Babergh District Council and Mid Suffolk District Council (20041302)

Deadline 8 submission for Bramford to Twinstead (EN020002)

The purpose of this submission is to present the councils' response in respect of the following items due at deadline 9:

TITLE  
 2.11.8 DESIGN AND LAYOUT PLANS: STOUR VALLEY WEST CABLE SEALING END COMPOUND

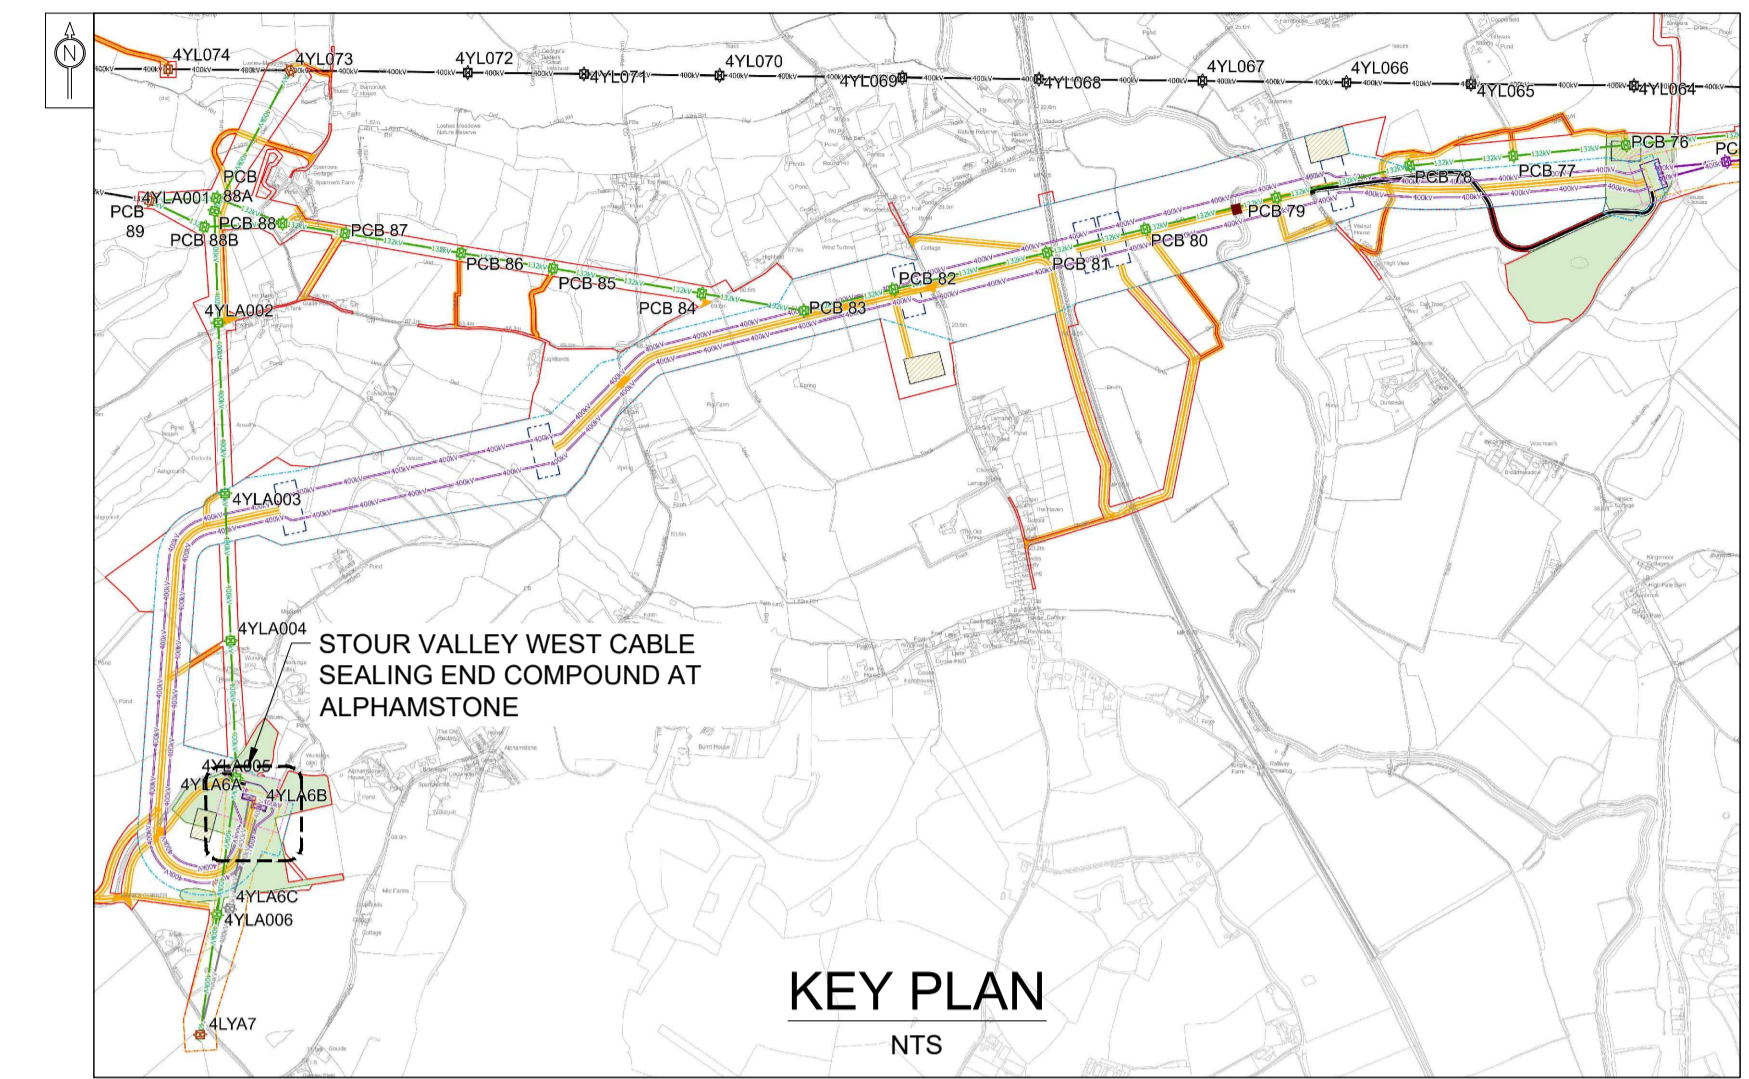
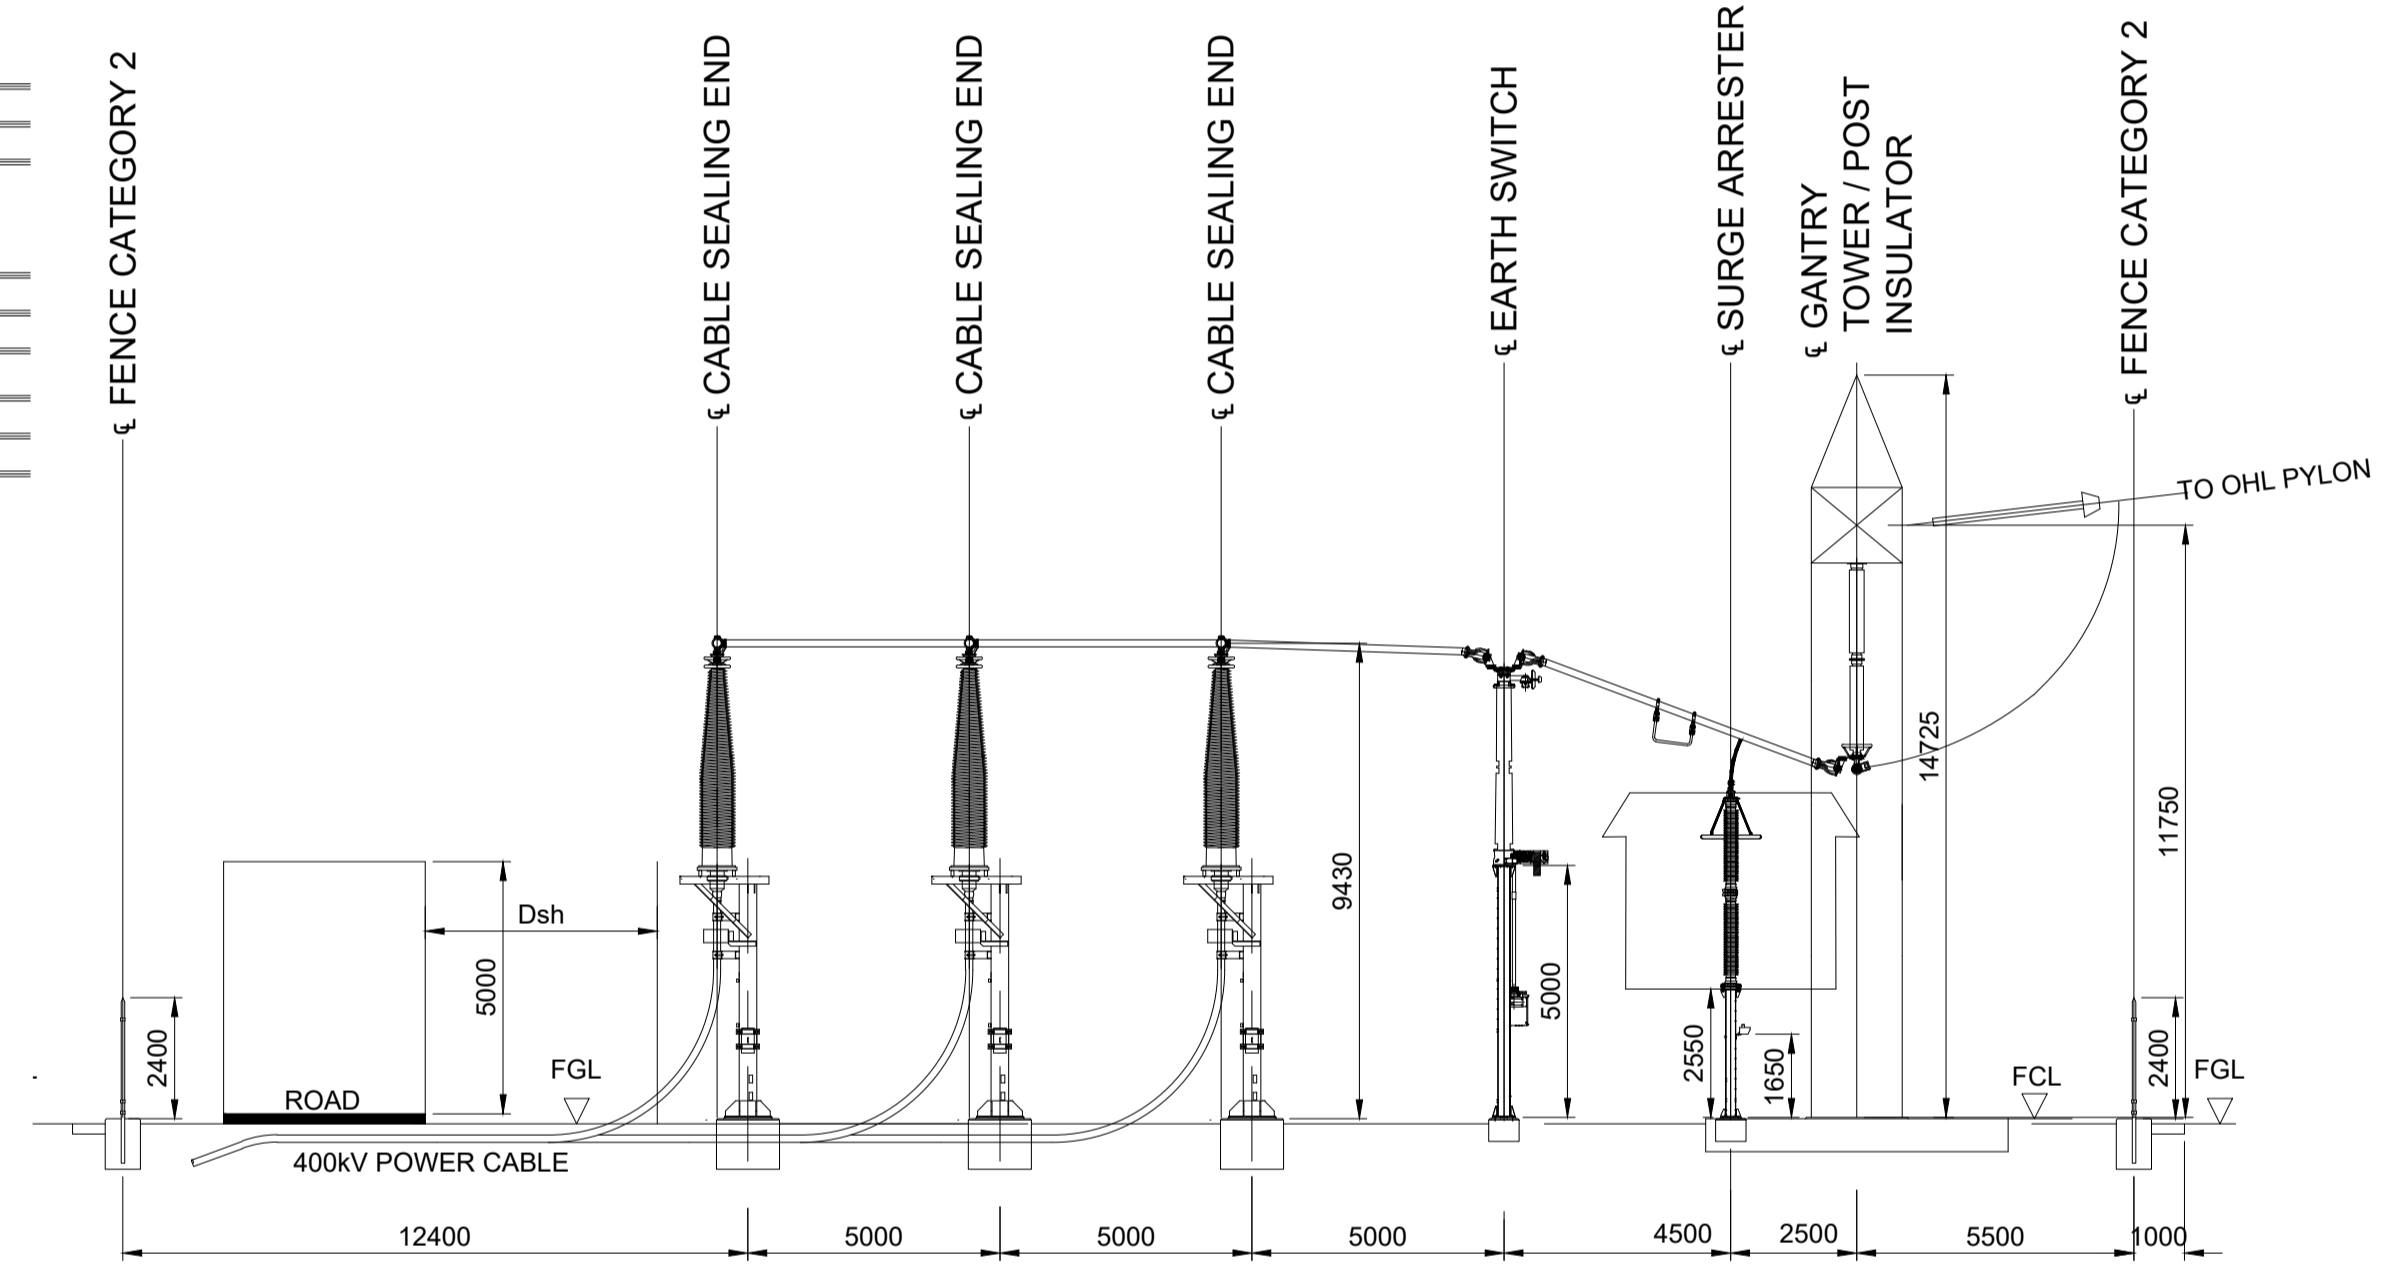
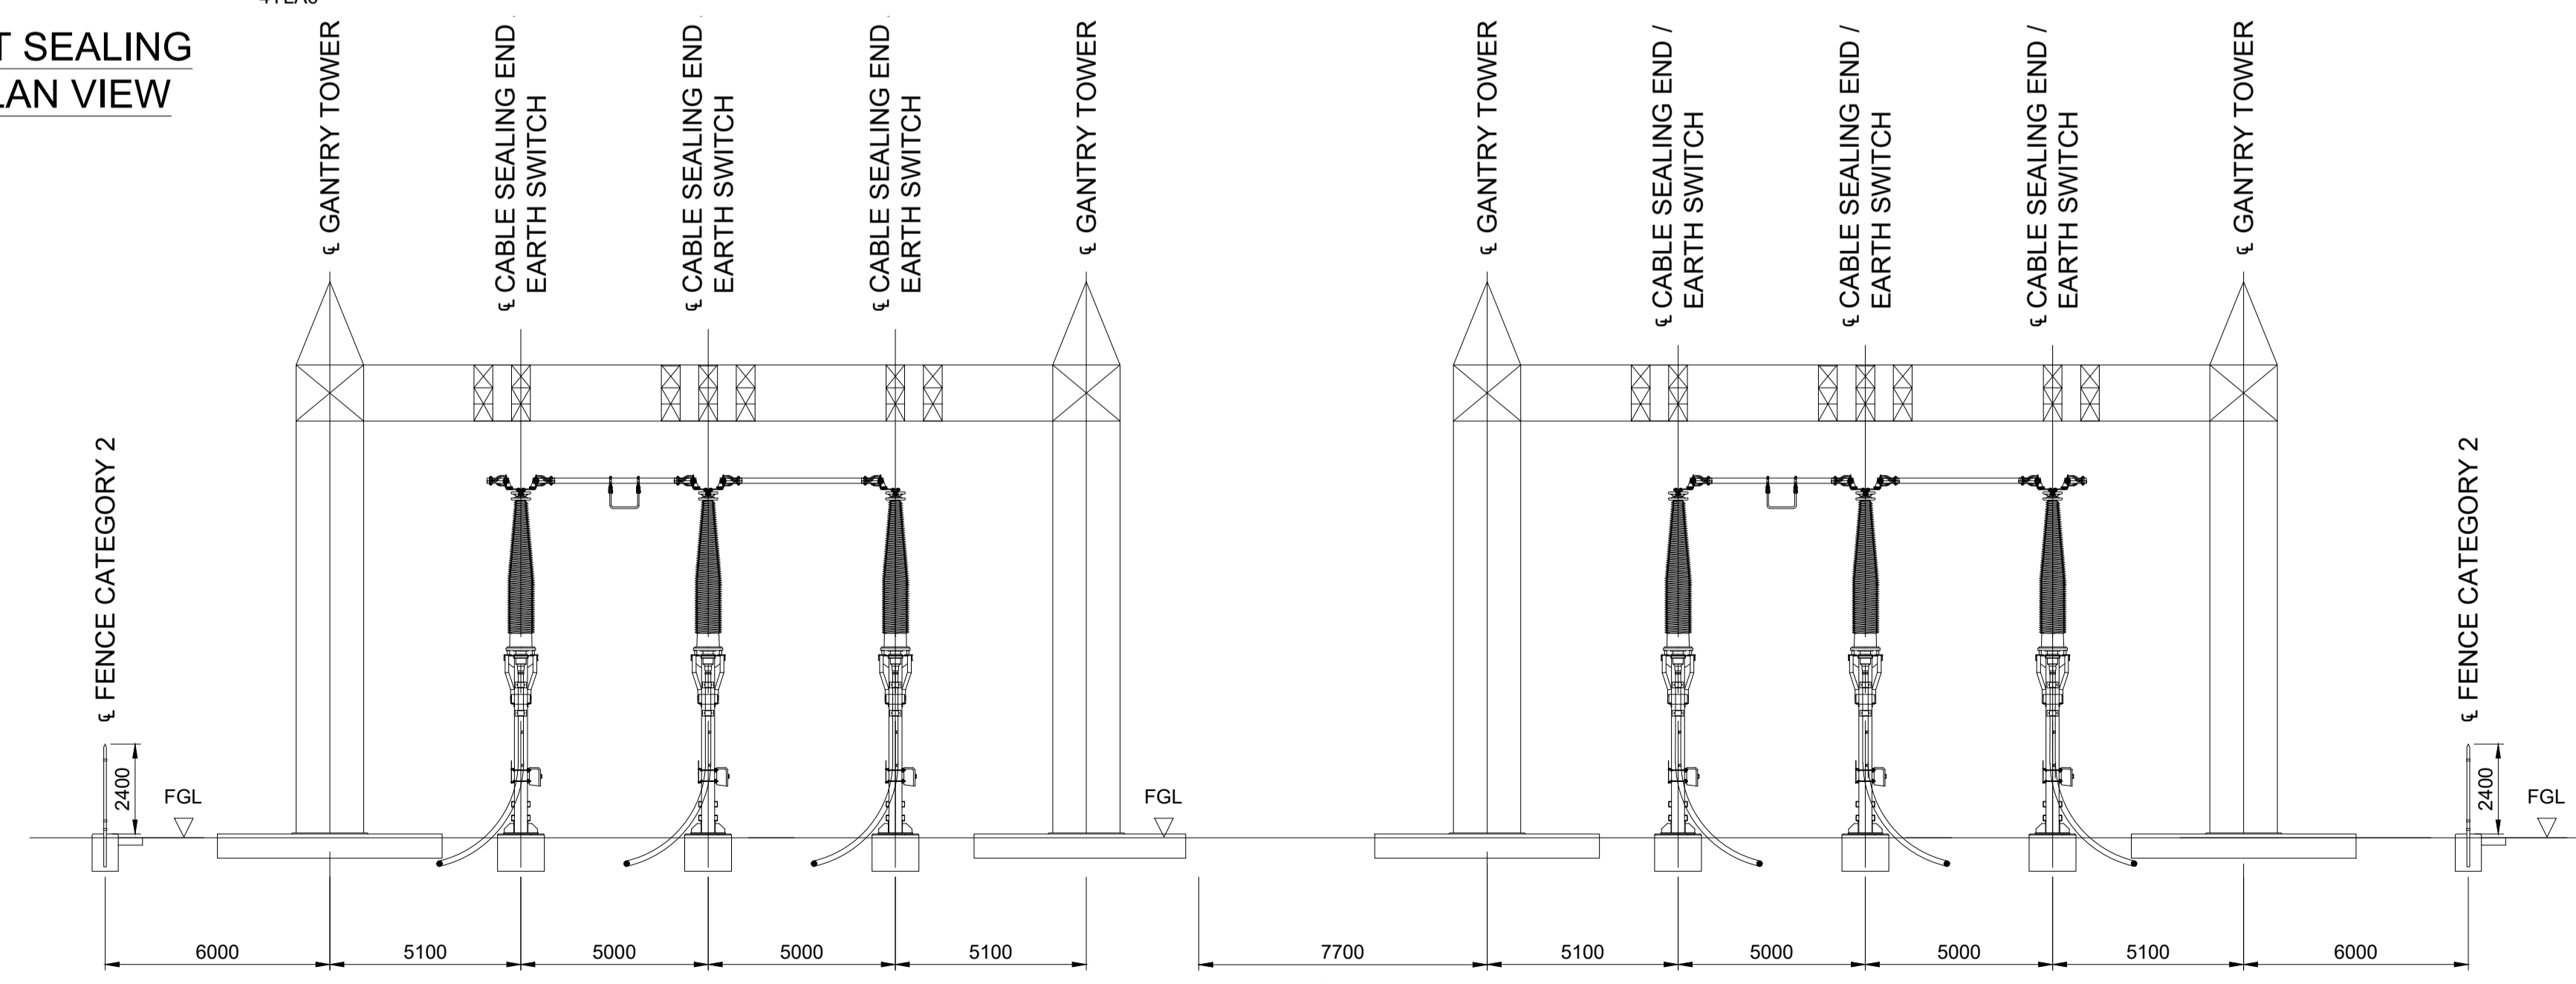
- LV2.9.3 Stour Valley West CSE – Essex County Council and Braintree District Council support SCC's call for additional tree planting at Stour Valley West CSE to extend the proposed landscape softening. The Applicant talks about only needing to mitigate significant effects but BMSDC, ECC and BDC maintain that as many adverse effects as possible should be mitigated or compensated for, and that the recently published Overarching National Policy Statement for Energy (EN-1), in para 4.1.5, supports this position.
